**Consultation Response from KC,
Lead Local Flood Authority**

2025/93470 Castle Hall, Lee Road, Ravensthorpe, Dewsbury, WF13 3BE

Change of use of existing care home (Use Class C2) to 11 self-contained residential flats (Use Class C3), including internal alterations

Date Responded: 18/02/2026.

P203

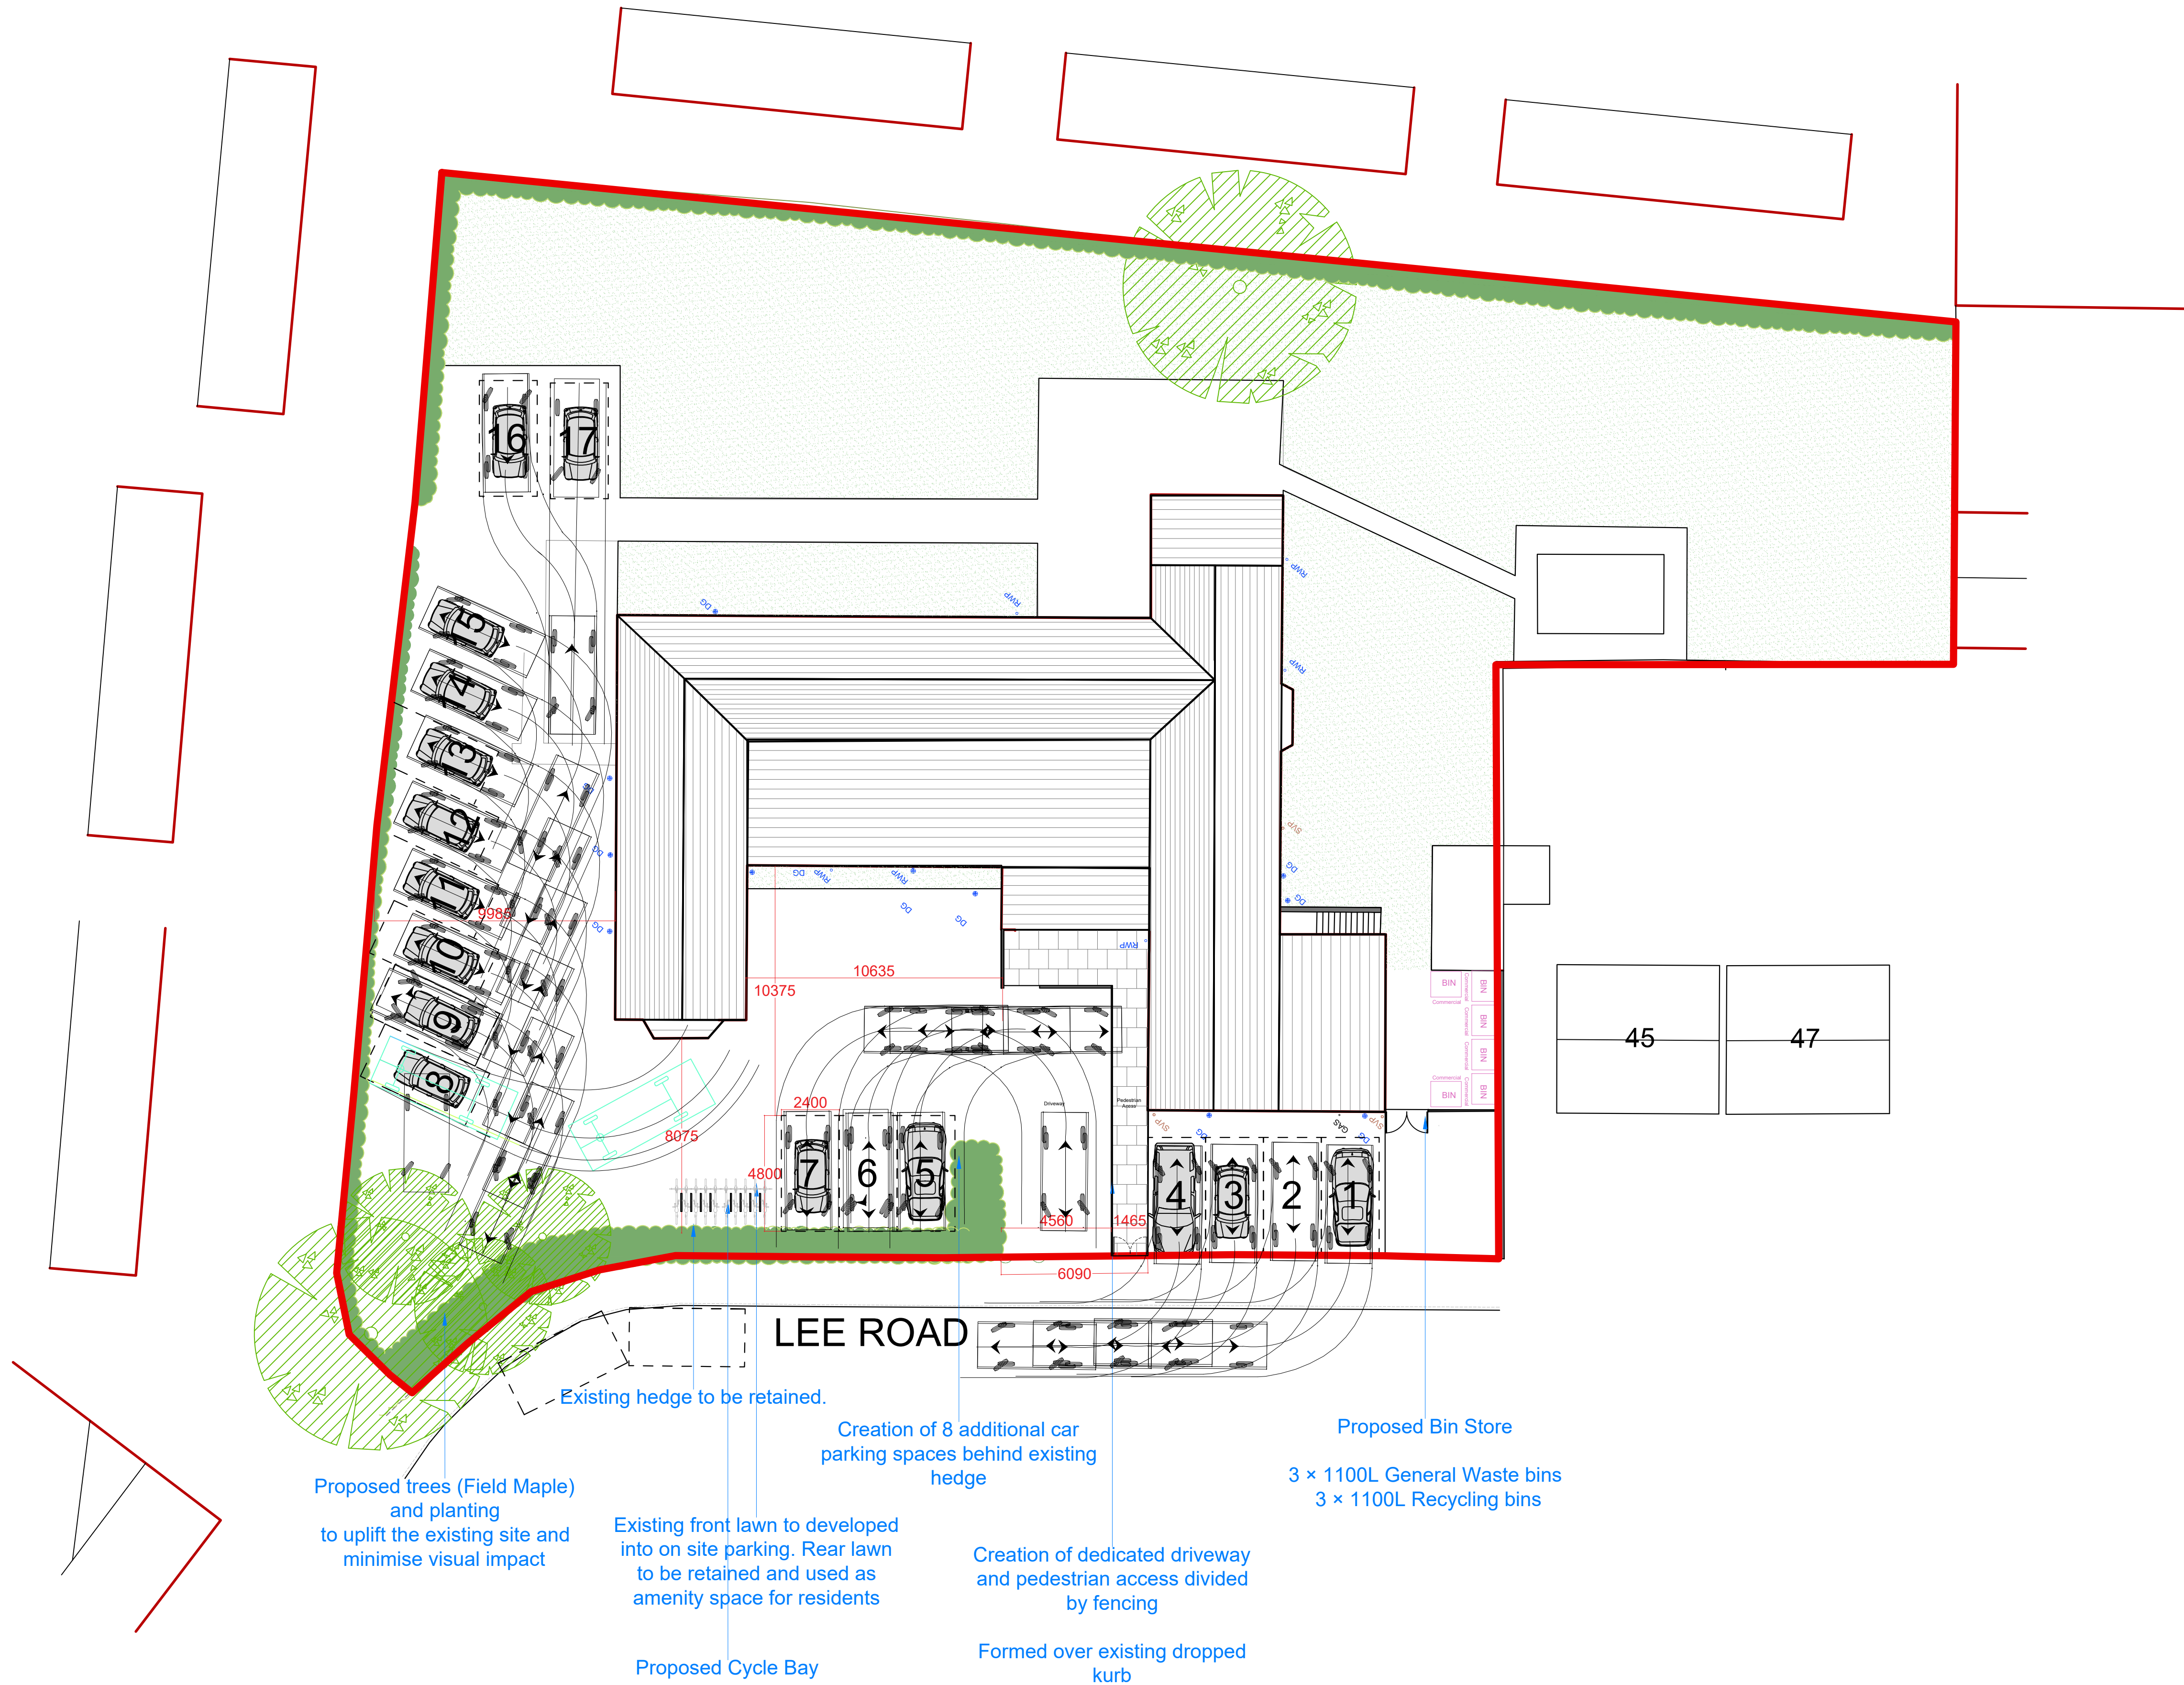
The proposal is for a change in use of an existing building (former Care Home) to residential use. There are no proposed changes to the building itself, however there will be an additional 50m² of new parking/hardstanding along the frontage of the property along Lee Road. This increase in drained area is too small to warrant any attenuation of flows; therefore, no drainage conditions are proposed by the LLFA.

The developer is reminded that surface water from the new parking/hardstanding areas should not drain directly onto the public highway.

Kirklees Council records indicate that the soils in this area may be suitable for moderate infiltration into the ground (subject to permeability testing) and therefore the developer may consider a permeable surface to the parking/hardstanding areas if testing proves this is viable.
